From: info@wilpshireparishcouncil.org.uk
Sent: 27 November 2025 12:38
To: Planning
Cc: info@wilpshireparishcouncil.org.uk; 'wilpshire parish council'
Subject: PLANNING CONSULTATION RESPONSES FROM WILPSHIRE PARISH COUNCIL

3/2025/0801, Land to east of Salesbury View Wilpshire BB1 9PJ - The application is for - Proposed erection of new residential development comprising 80 new homes, including 30% affordable housing, open space and associated infrastructure.

WPC – Object to this application for the following reasons:

Drawing Title
**DRAINAGE LAYOUT
SHEET 1**

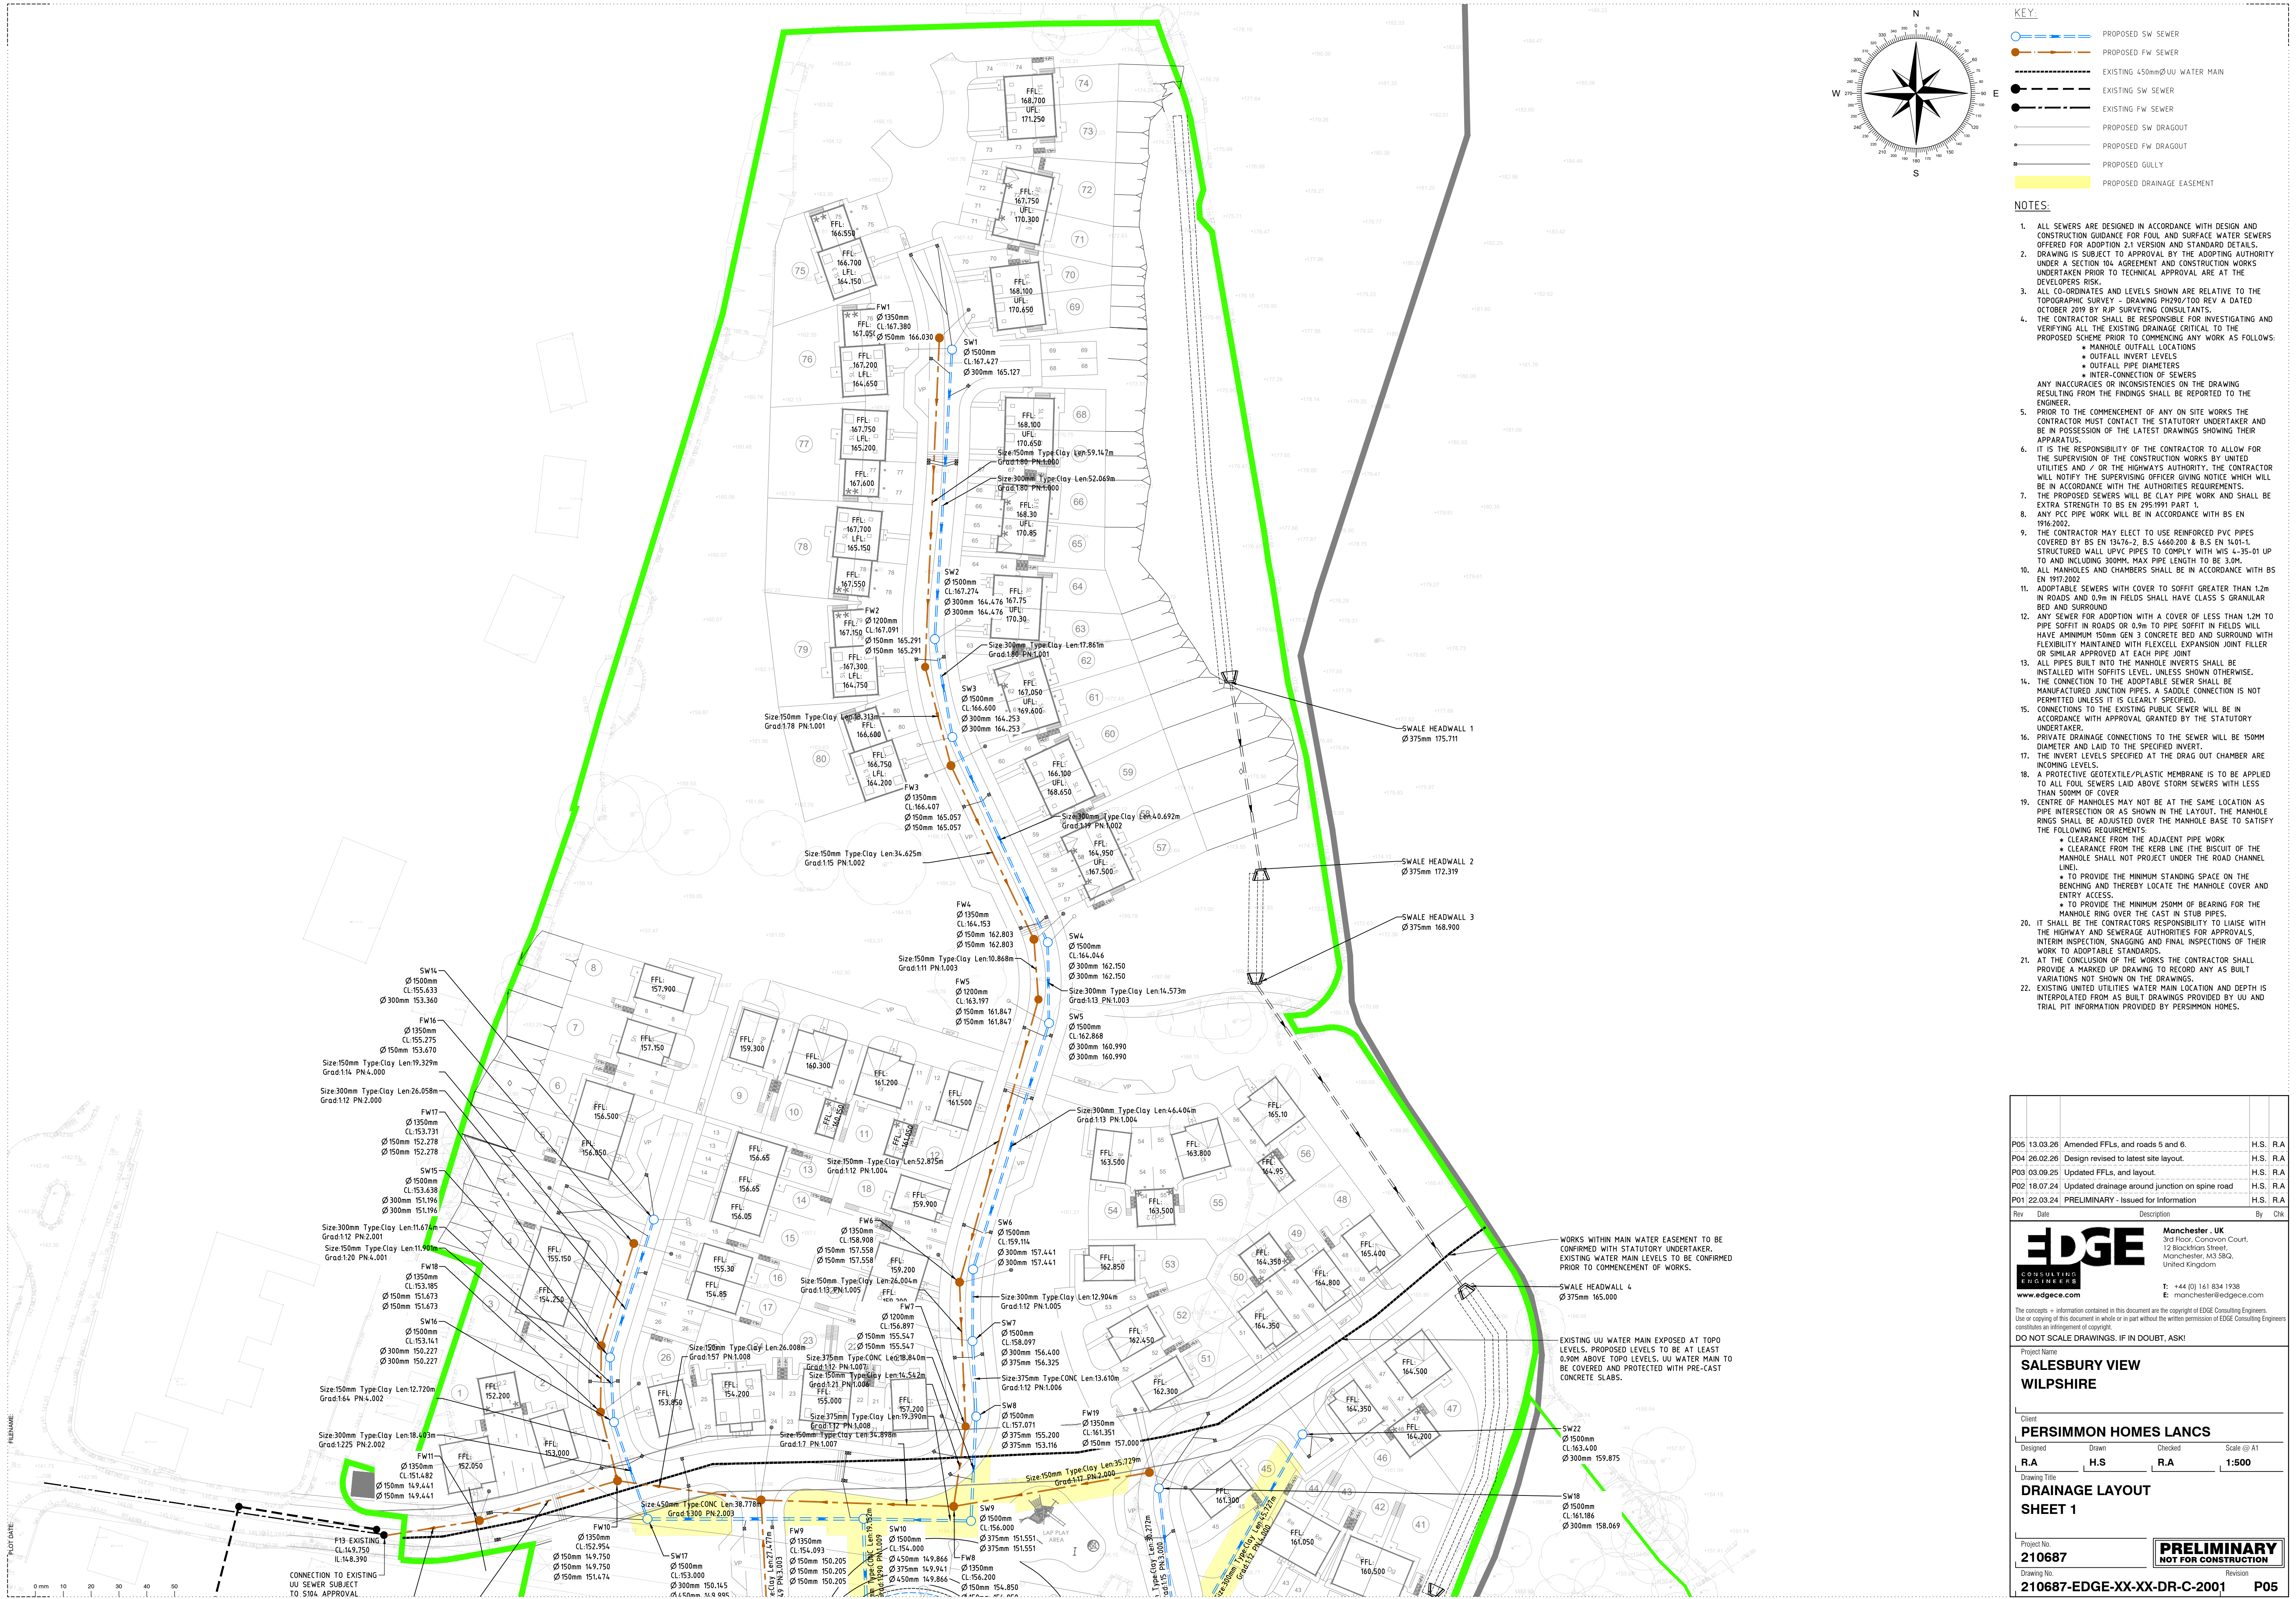
7-There is a significant flood risk due to the steep nature of the site with drainage likely being overwhelmed in times of high rainfall, creating an ice rink in winter.

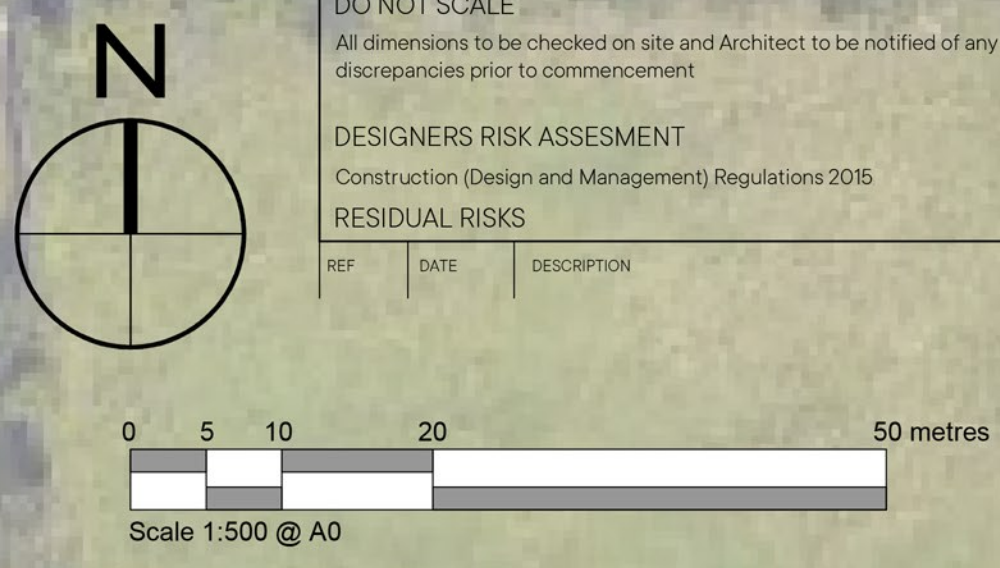
6-There is a very large volume United Utilities Trunk water main running through the application site- the route of this pipe has not been exactly determined by United Utilities and may affect the proposed layout as UU will not allow building over or in close proximity to their infrastructure.
